**Our ref:** Q080666 el/hr  
**Your ref:** 19/01740/HYBRID and 19/01746/OUT  
**Email:** emma.lancaster@quod.com  
**Date:** 19 November 2019

## **Catalyst Bicester, Response to Consultation**

Further to the submission of the two planning applications referenced above and ahead of our meeting on 27 November, please find enclosed our response to the comments received from consultees to date.

10 No. Cycle hoops, to accommodate 20 No. bikes

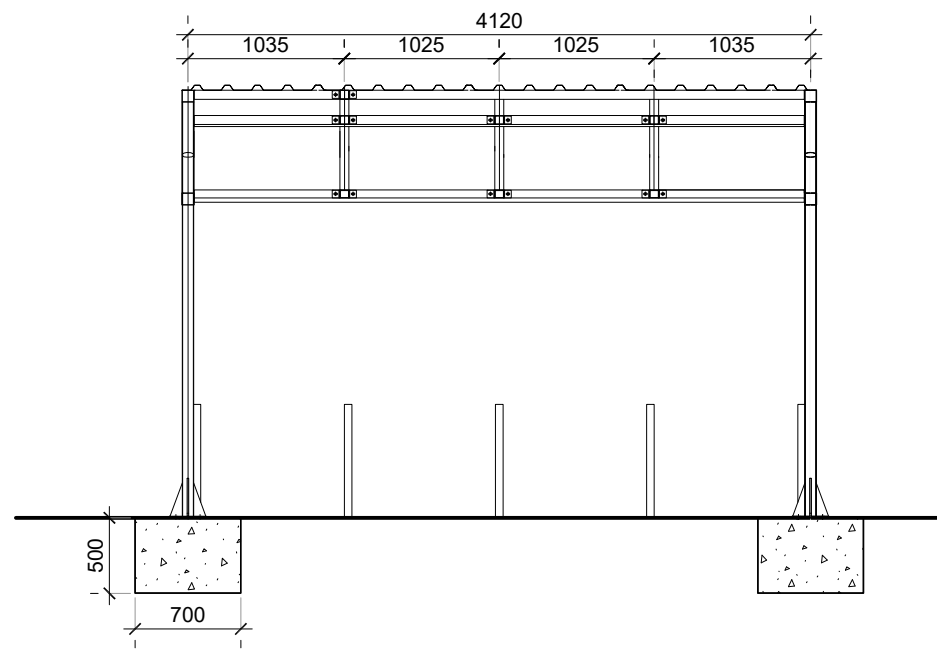
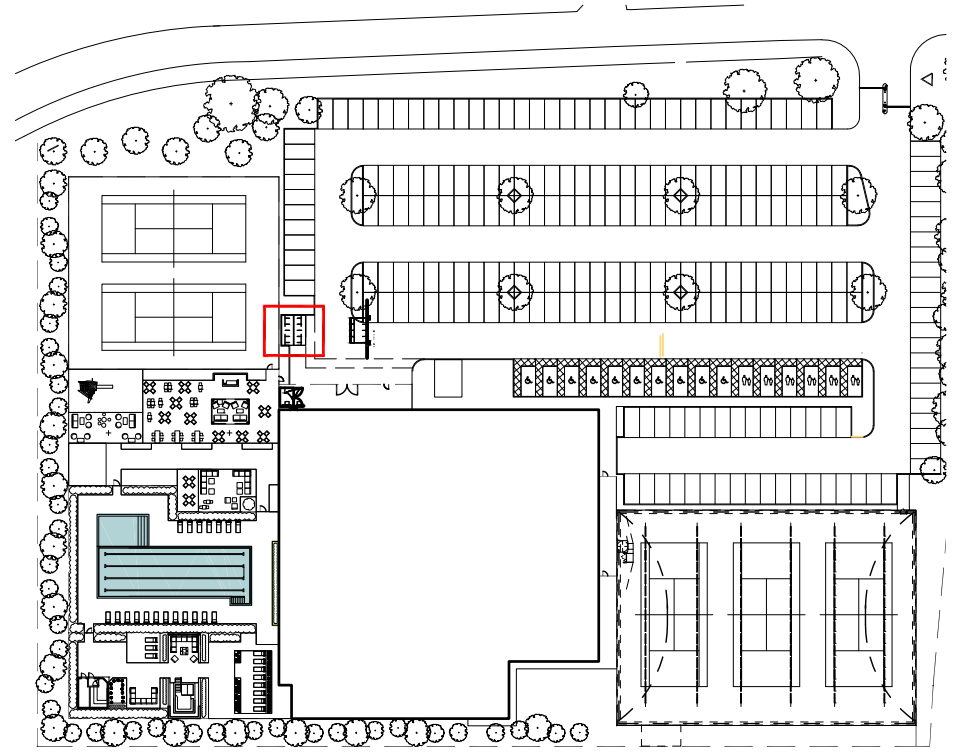
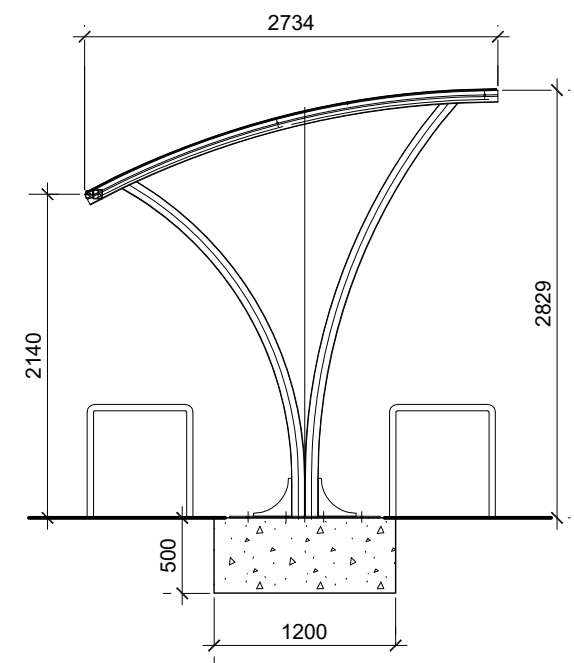
**iv. 20 cycle parking spaces are insufficient**

It is important to clarify that the referenced 20 cycle parking spaces are only those proposed for the Health & Racquet Club, and not for the whole site. Whilst this is less than the recommended cycle parking provision in the OCC standards, these do not differentiate between large footprint health clubs and small-scale gyms, for whom, we would suggest, the standards are more directly relevant.

This provision is based on experience and take-up at existing David Lloyd Health & Racquet Club sites to be sufficient and appropriate. It is proposed that the Travel Plan for the Health & Racquet Club will include a review of the take up of the cycle parking spaces and will increase provision where there is demand.
